REQUEST

Current Zoning: N1-A (neighborhood 1-A)
Proposed Zoning: INST(CD) (institutional, conditional)

The petition proposes to allow the renovation and expansion of an existing assisted living/independent living senior facility.

Carmel Hills, Inc.

# RZ-2

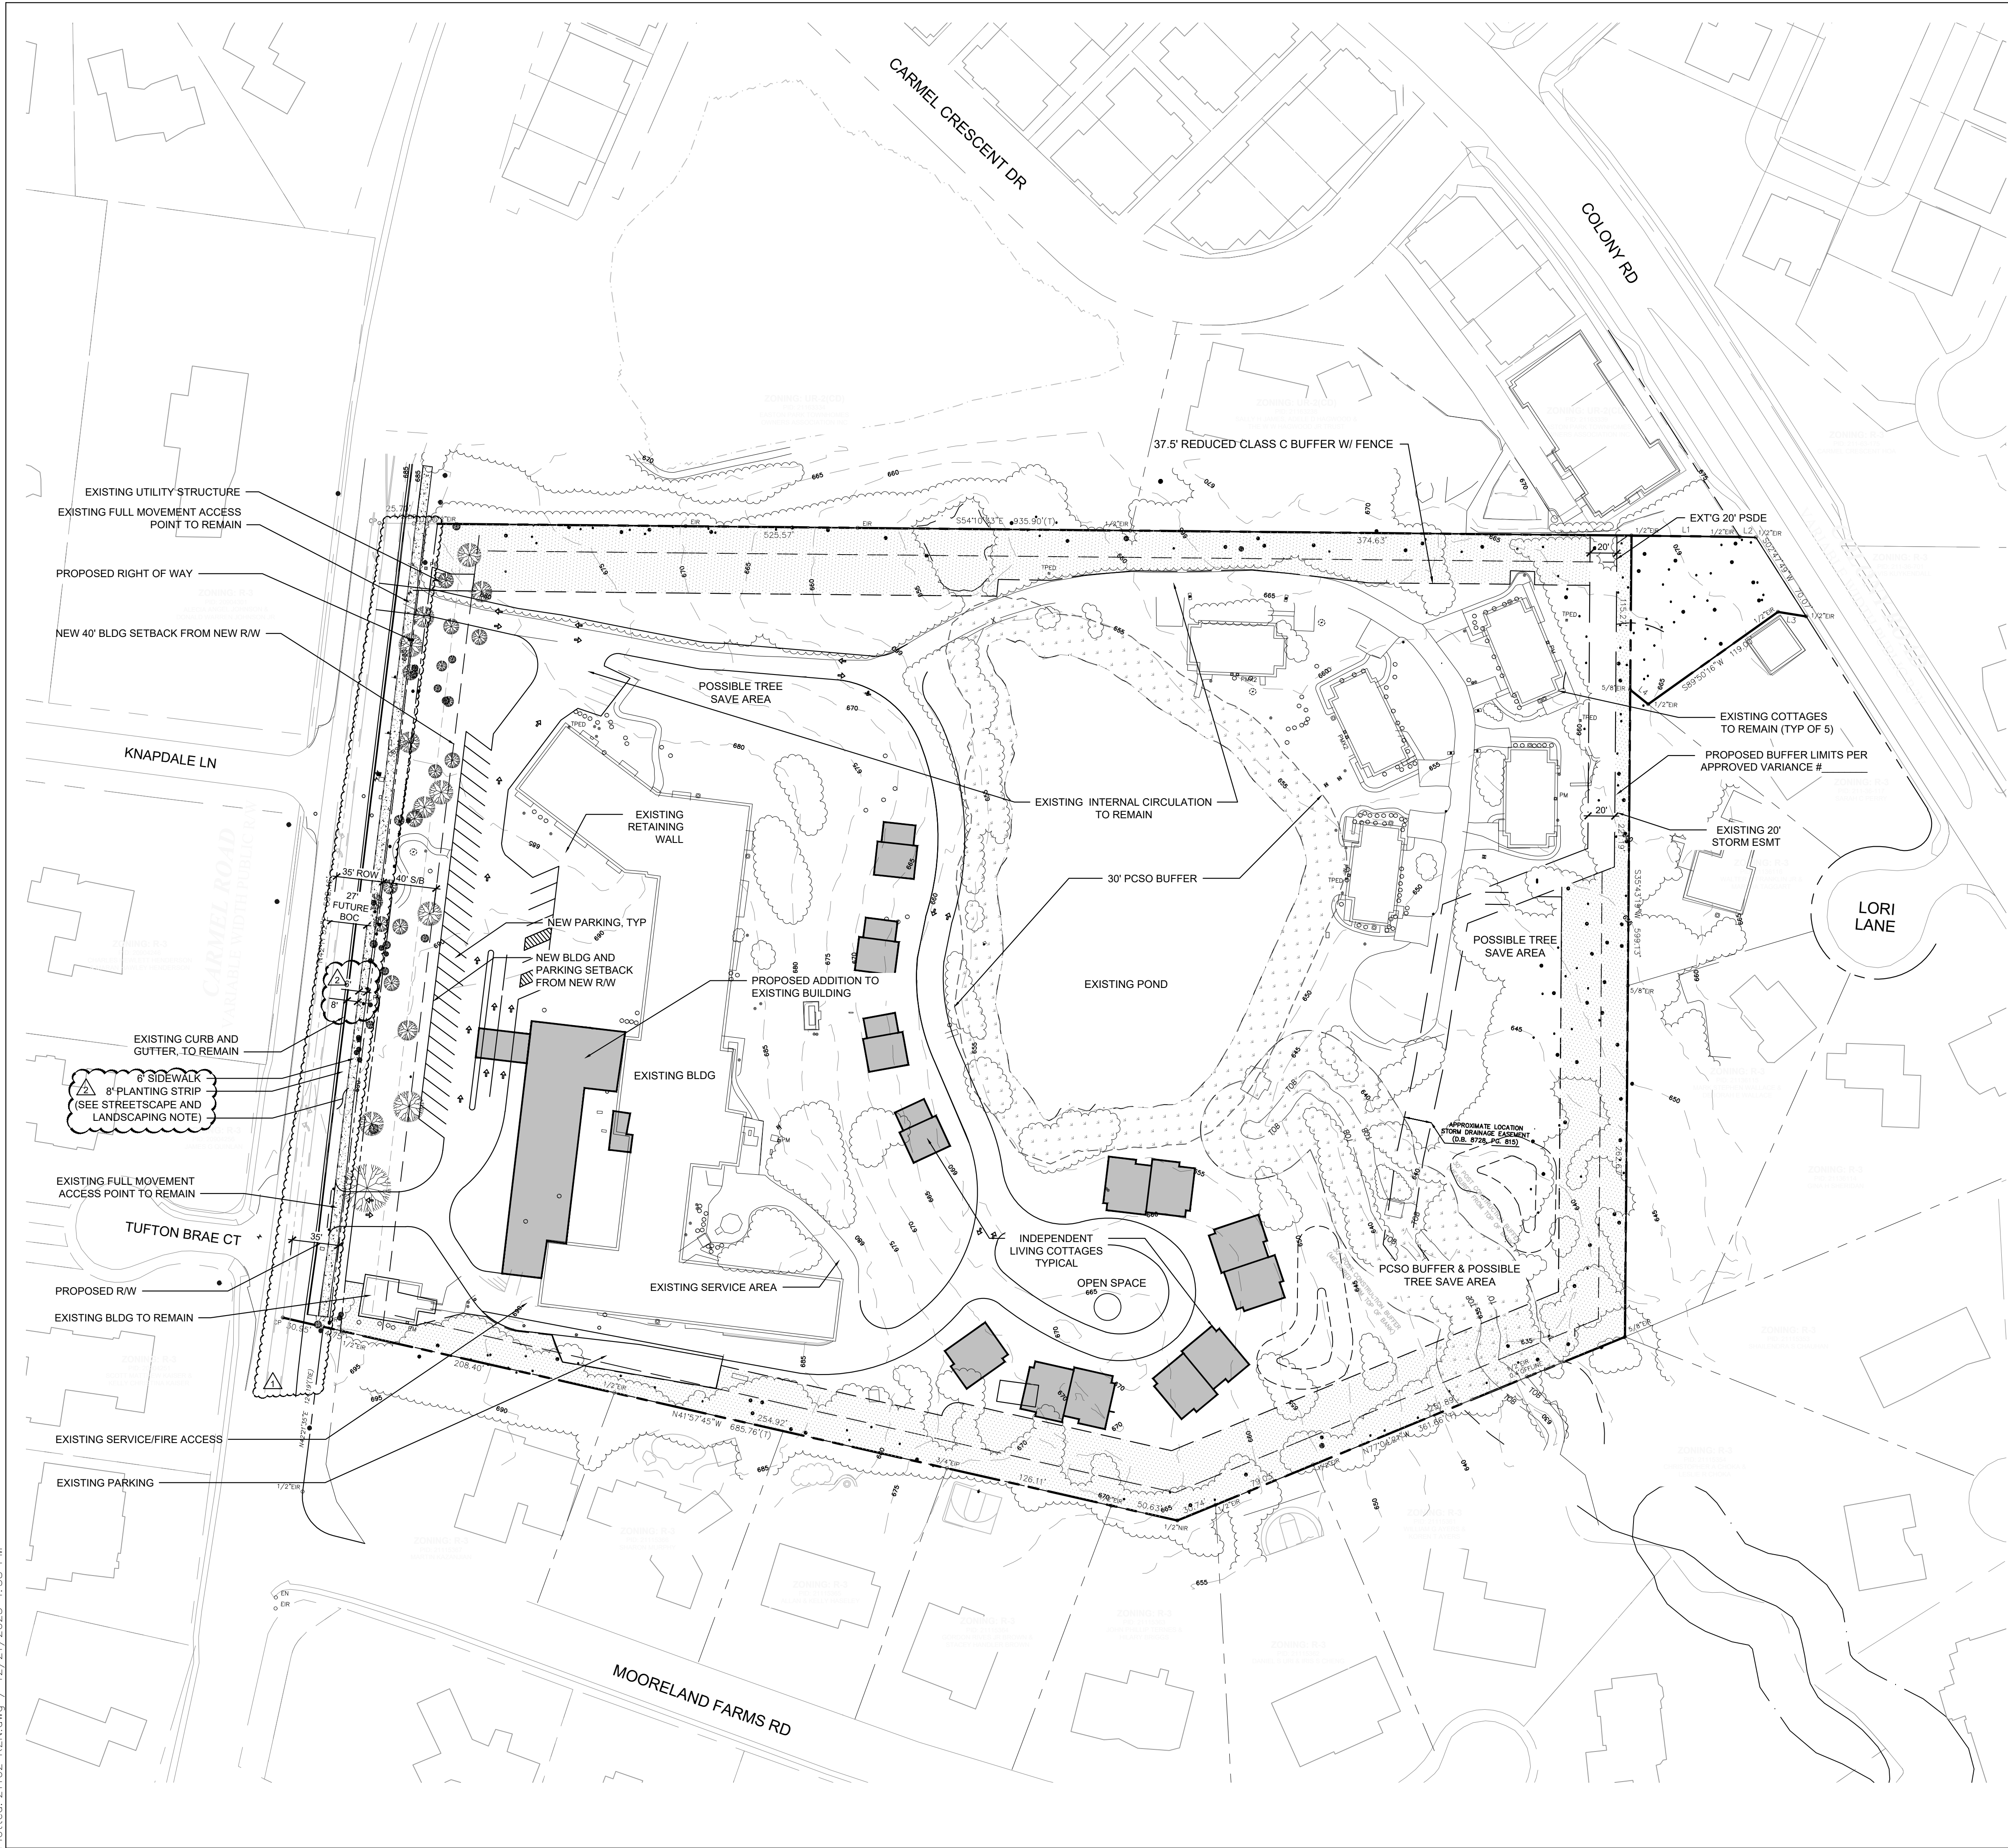
1. ~~Colony Road: Location of future curb and gutter to be moved to 24 feet from roadway centerline to accommodate the Charlotte Streets Map with a roadway typical section of CLDSM 11.09 Minor Thoroughfare. Per Chapter 19 revise site plan and conditional note(s) to commit to construct an 8-foot planting strip, and 6-foot sidewalk on Carmel Road and Colony Road.~~ **ADDRESSED**

2. ~~Revise site plan and conditional note(s) to commit to dedicate 43 feet of right-of-way from the Carmel road centerline and 40 feet of right of way from the Colony Road centerline. The site plan shall label and dimension the right of way from the road centerline.~~ **ADDRESSED**

3. ~~Request to revise site plan and conditional note(s) to commit to construct a buffered bicycle facility along Carmel Road by locating the back of curb and gutter 27' from the center line to meet the Council-adopted Charlotte BIKES Policy.~~ **ADDRESSED**

4. ~~Add a conditional note specifying "All transportation improvements will be approved and constructed before the site's first building certificate of occupancy is issued. The petitioner may phase transportation improvements if said improvements and phasing are explicitly described in site plan notes."~~ **ADDRESSED**
